Marge Schmuckal - 18 Taylor Street permit application

From: Marge Schmuckal
To: glendalecorp@gmail.com
Date: 7/18/2013 5:15 PM
Subject: 18 Taylor Street permit application

057-B-000

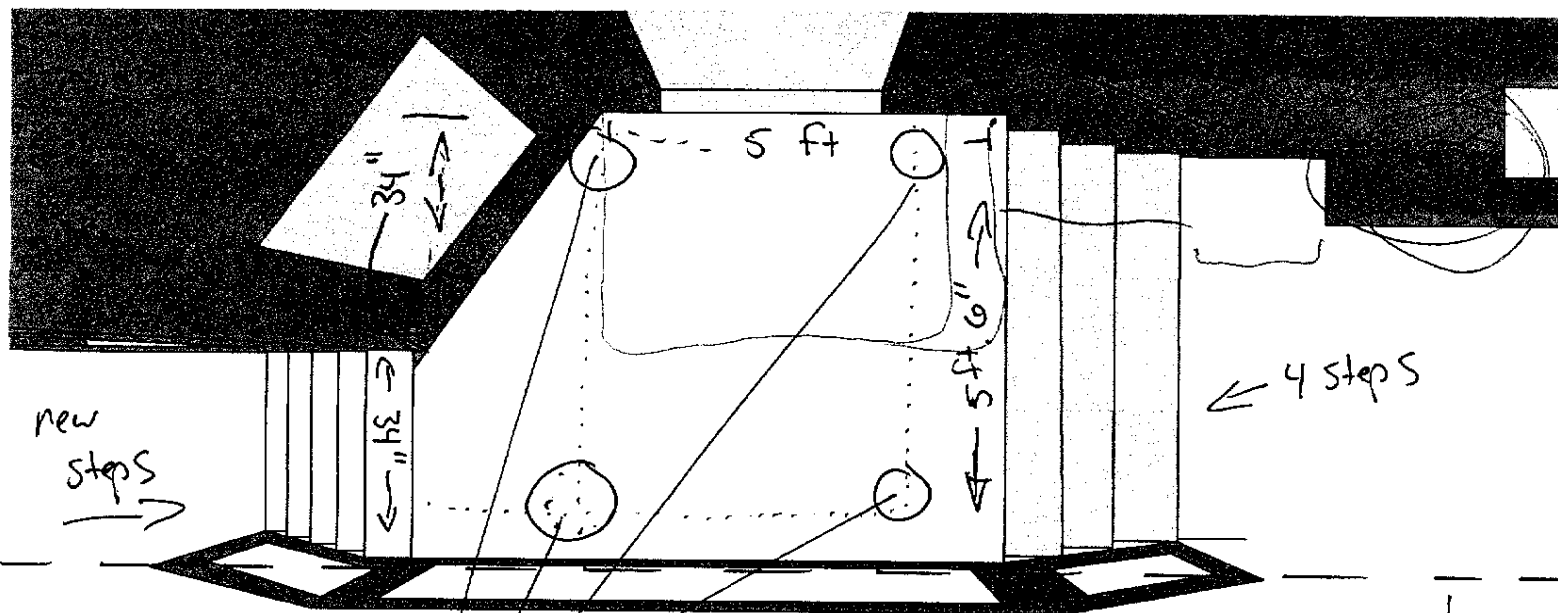
I am in receipt of your application to rebuild and increase the size of the side entry way at 18 Taylor Street. Your plans are not fully dimensioned. Only the platform is dimensioned. Without accurate, dimensioned plans I can not determine compliance with the R-6 zoning requirements. Normally any expansion would need at least a five (5) foot setback. However another section of the Ordinance allows a 50 square foot structure to be located within the setback as long as it does not extend further that 6' from the building.

Your permit is on hold until I can receive better plans to help me determine whether you can meet the Land Use R-6 dimensional requirements.
